**RE: 815 Roger Griffiths Avenue
Urban Design Brief**

In support of the Site Plan Control Application for the lands at 815 Roger Griffiths Avenue in the City of Ottawa, please find our Urban Design Brief enclosed. Per the Urban Design Brief Terms of Reference received from City staff following the pre-consultation meeting taking place May 6, 2025, alternative site plan options and responses to the urban design direction provided are included below.

1.0 Response to Urban Design Directions

The following comments were received from staff as part of pre-consultation feedback dated June 2, 2025.

Sheet **L 1.0**

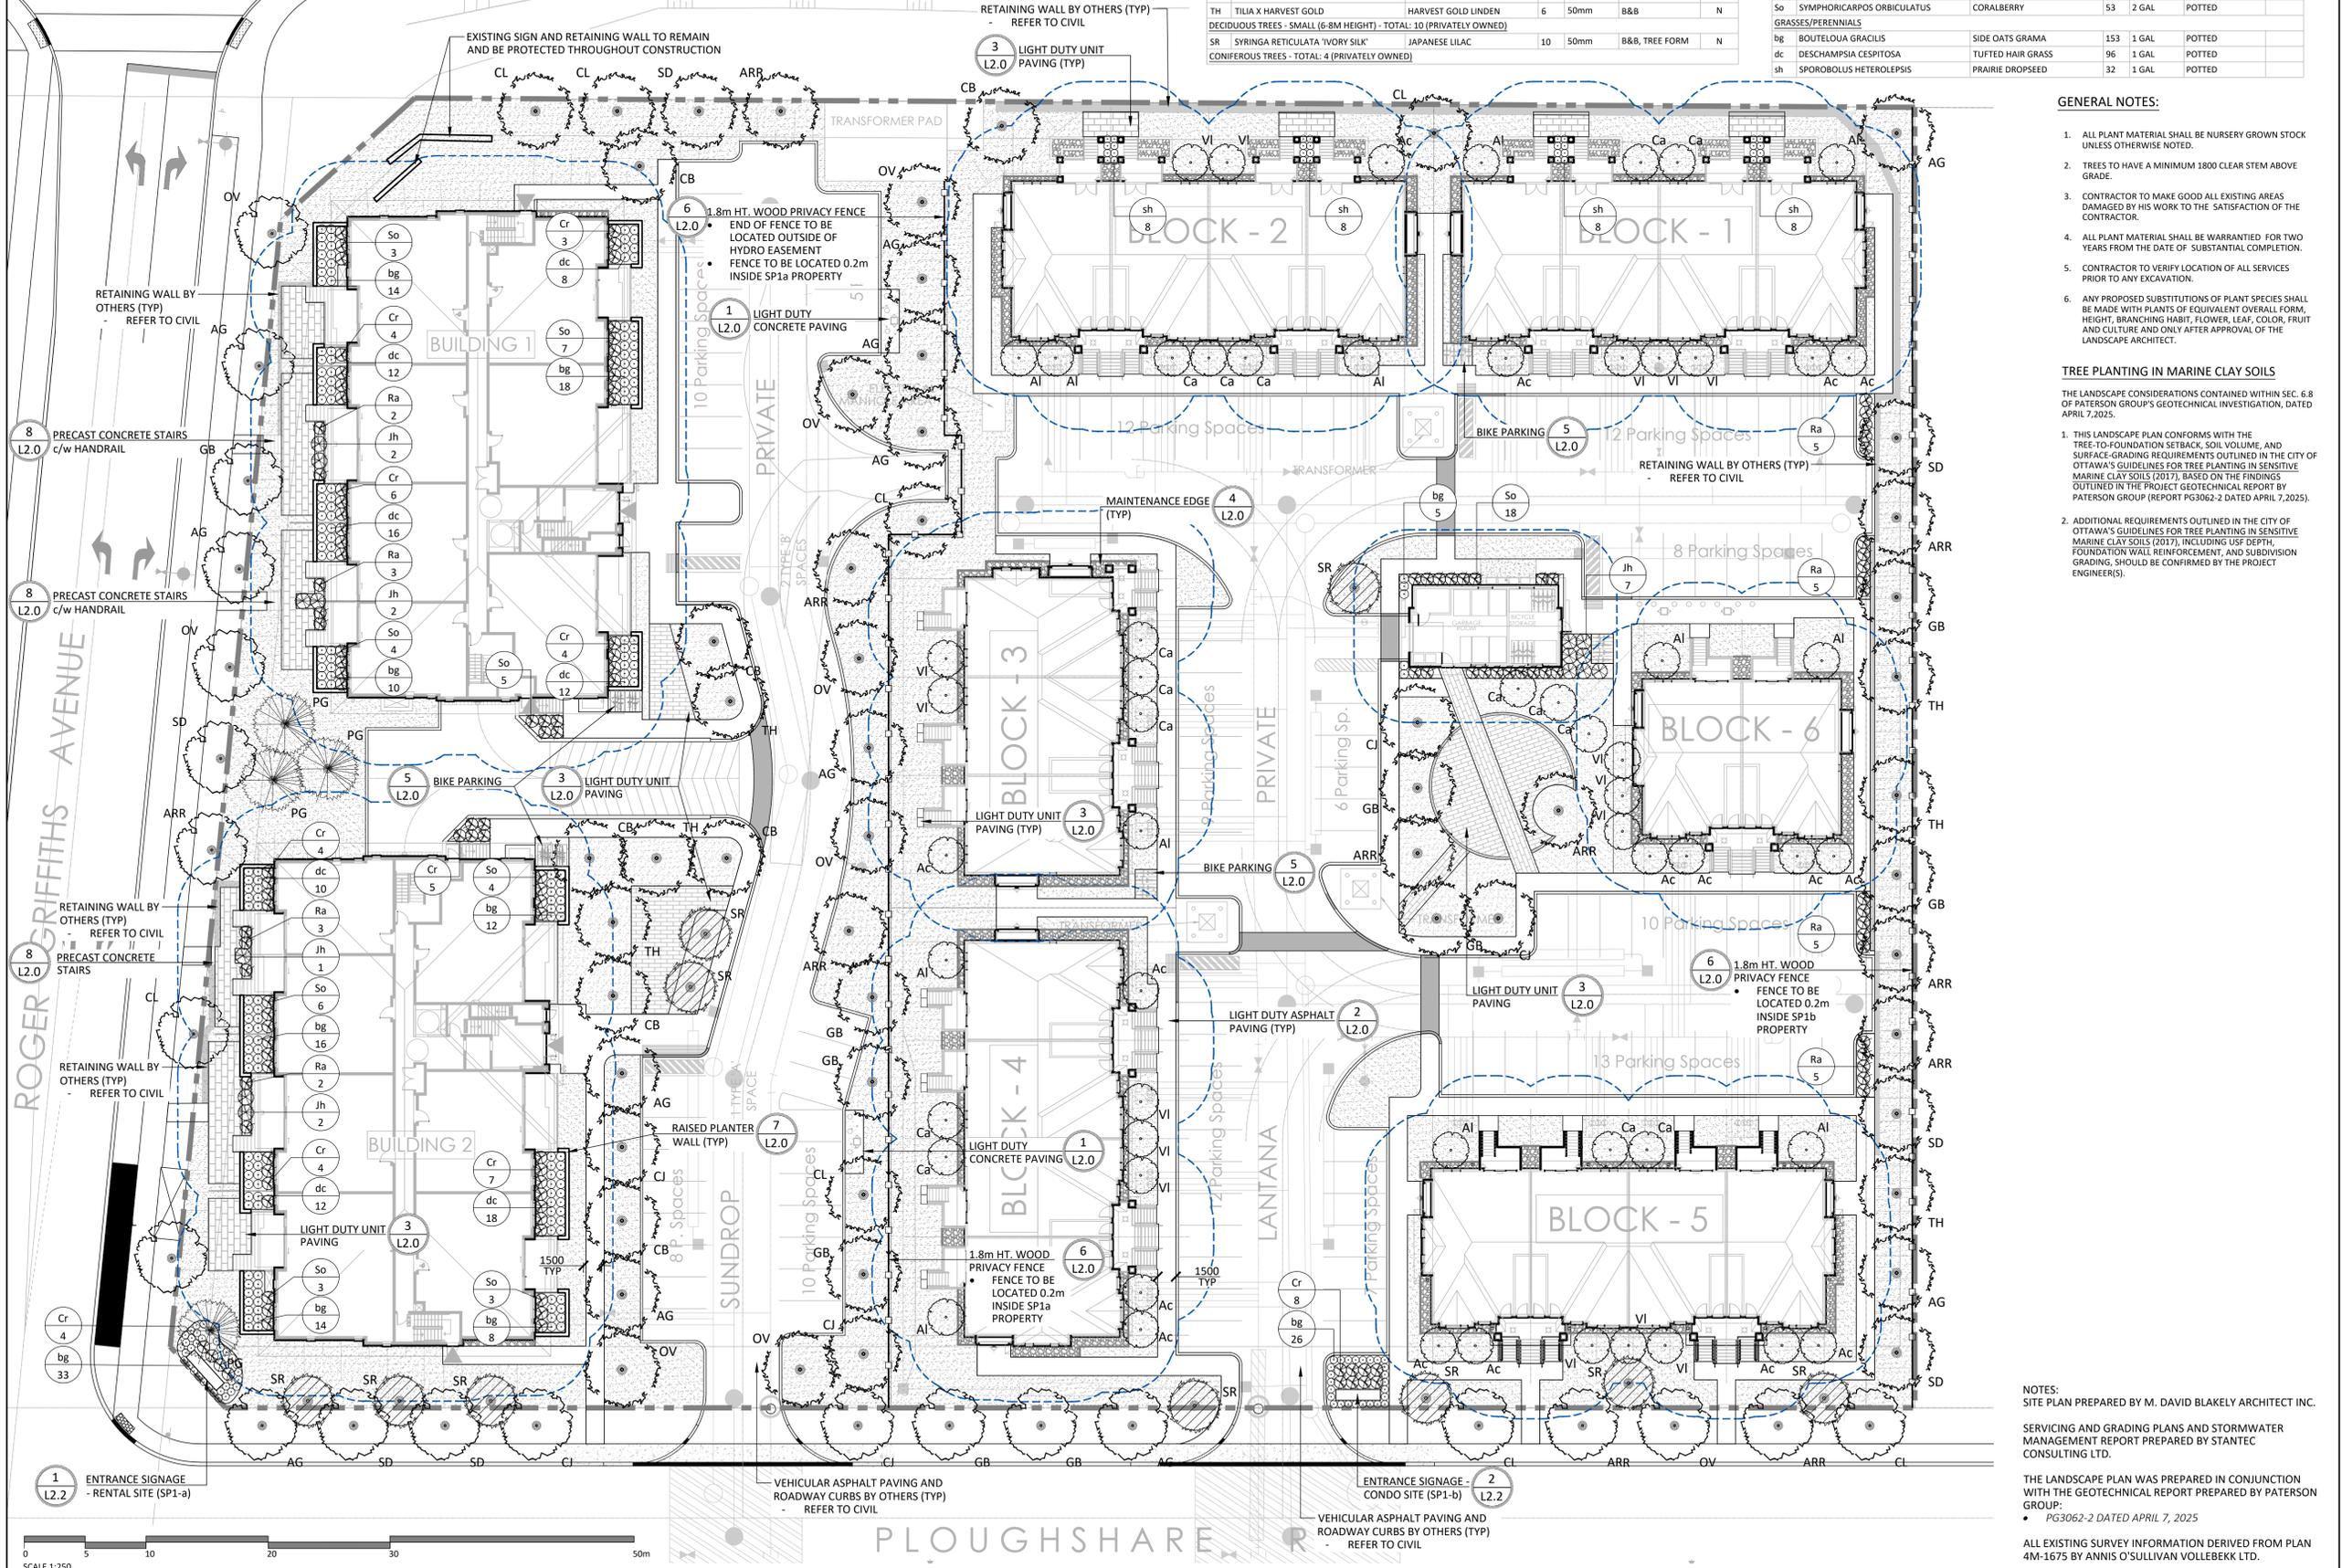
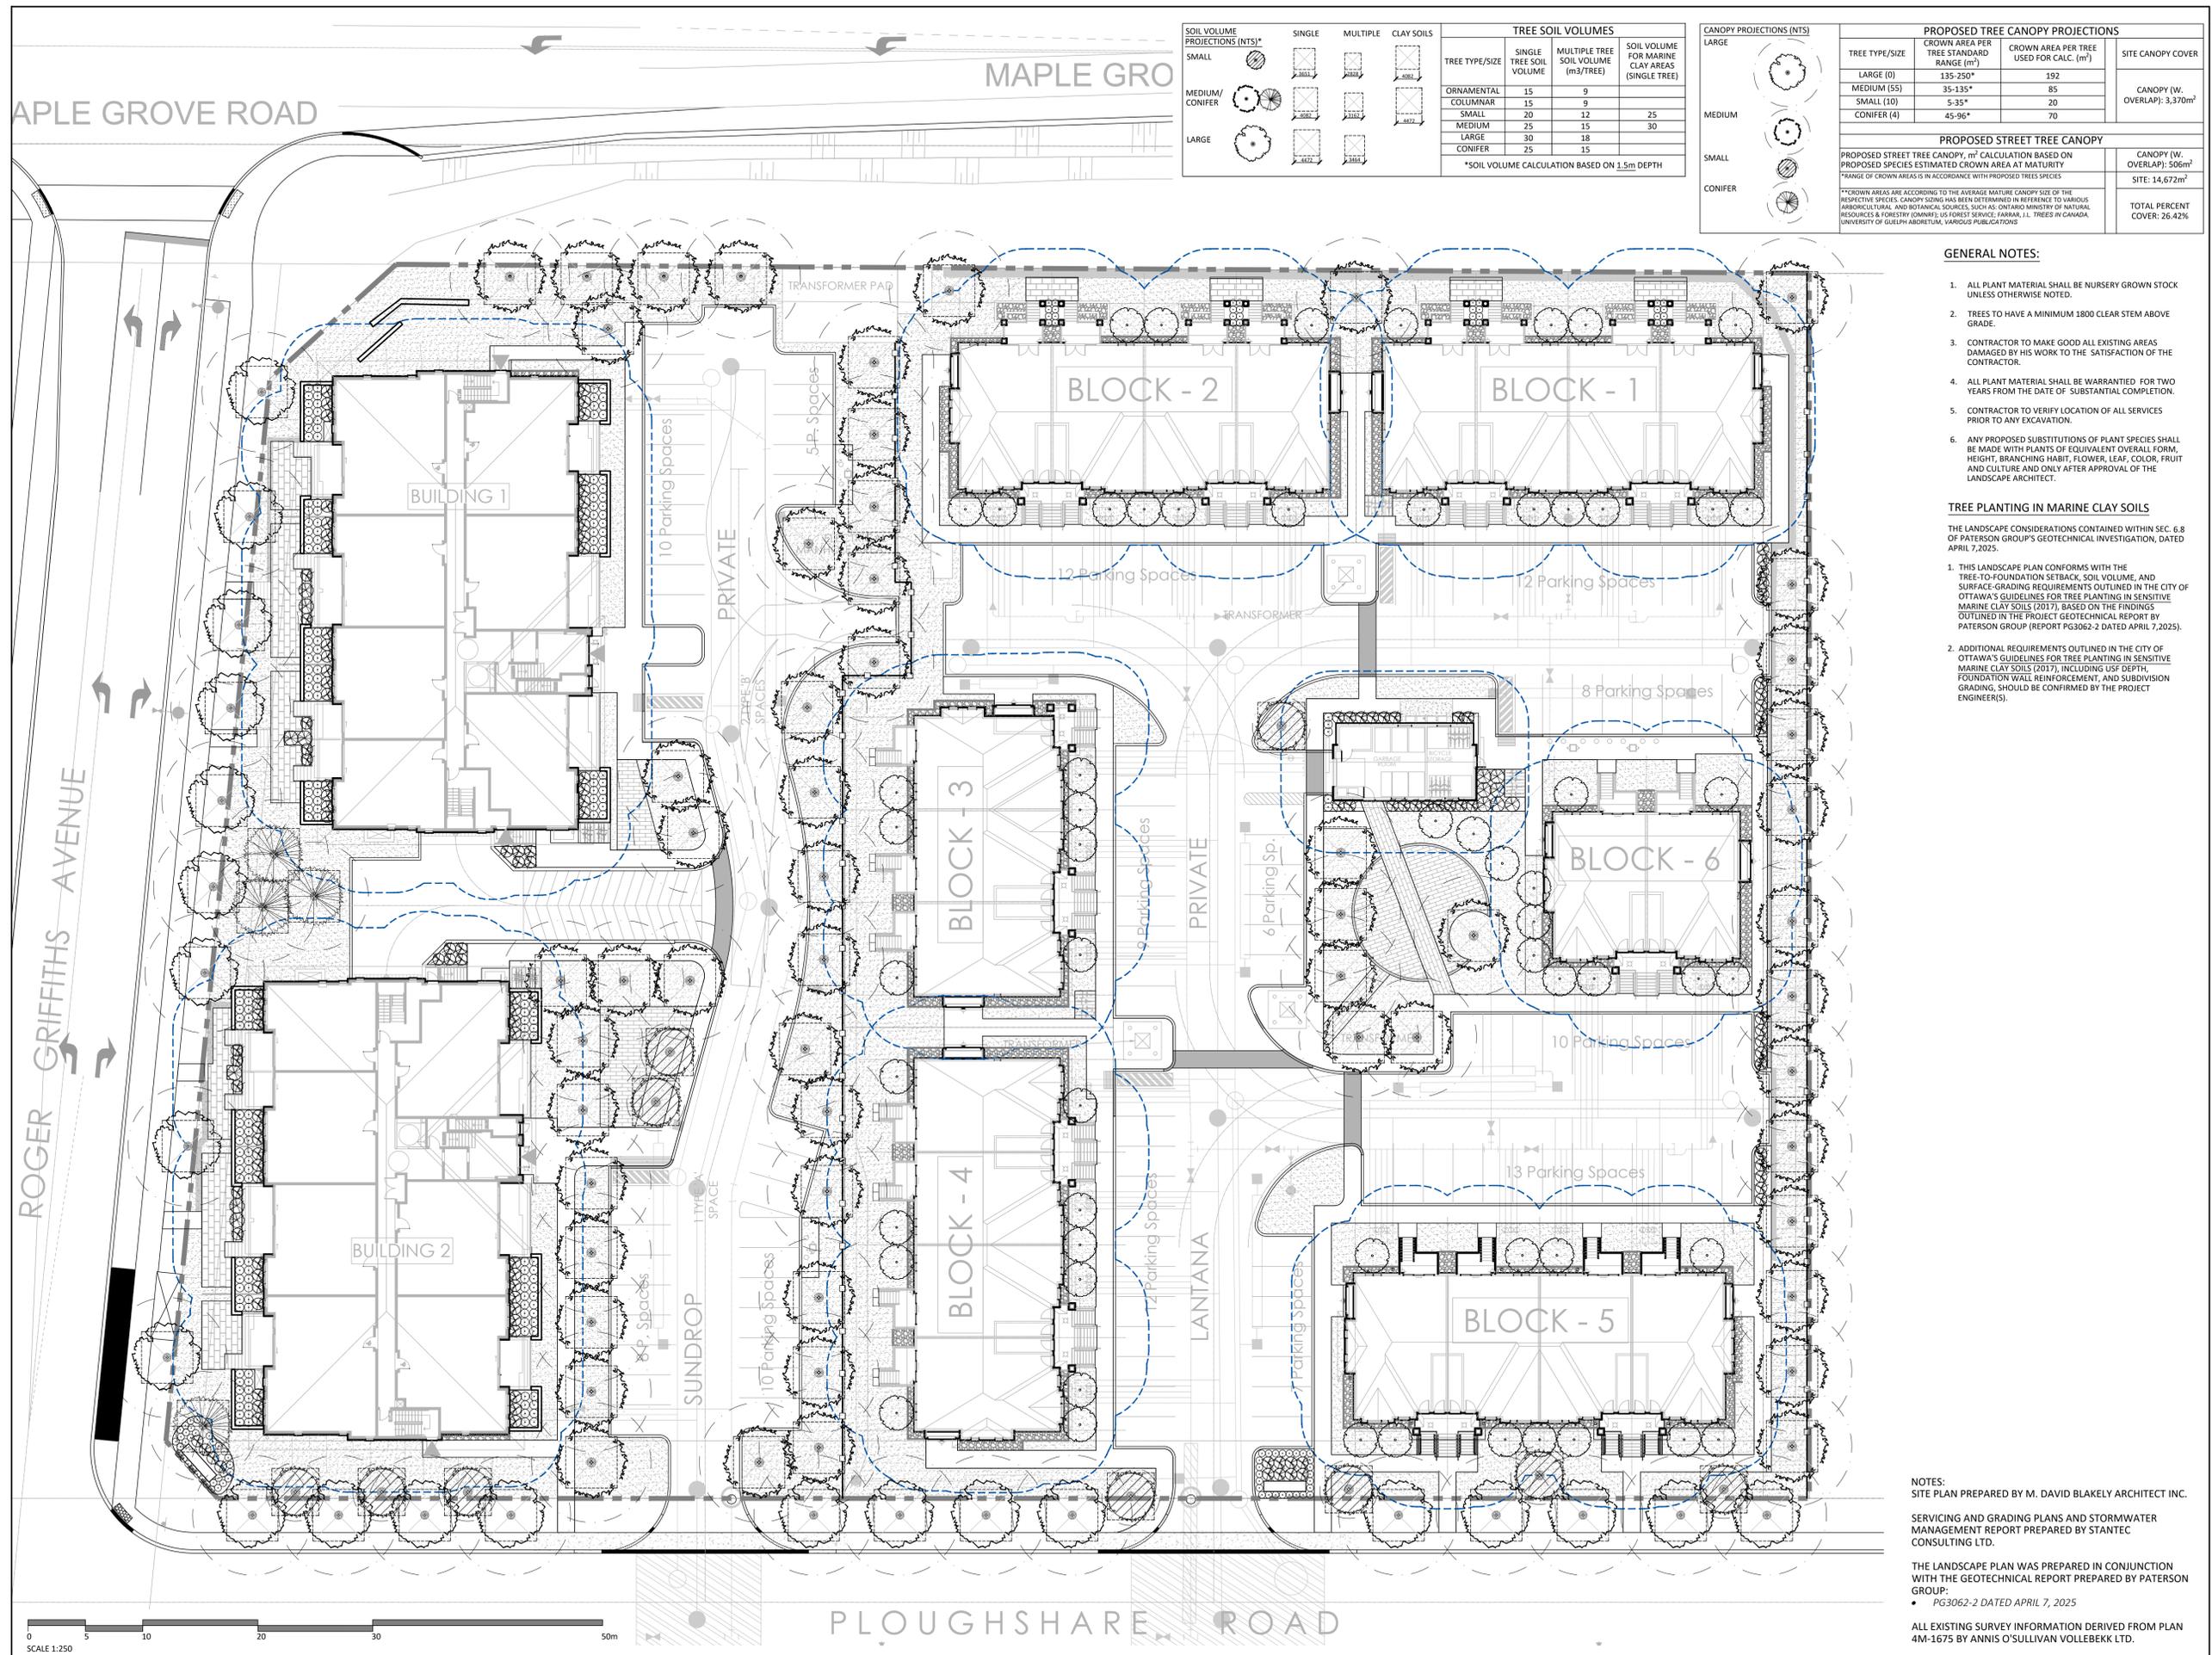
1.4 I recommend providing benches, gazebos, some means of shade, trees and landscaping within the amenity areas to ensure they are used as amenity and not just areas of sod.

1.5 I recommend illustrating all of the trees intended in the design on a landscape plan for review.

Amenity areas are programmed per the attached landscape plan, featuring enhanced walkways, seating, and medium canopy trees. The approach will be consistent with Richcraft's similarly scaled, high-quality amenity spaces throughout the City.

A landscape plan with planting details has been provided with this submission.
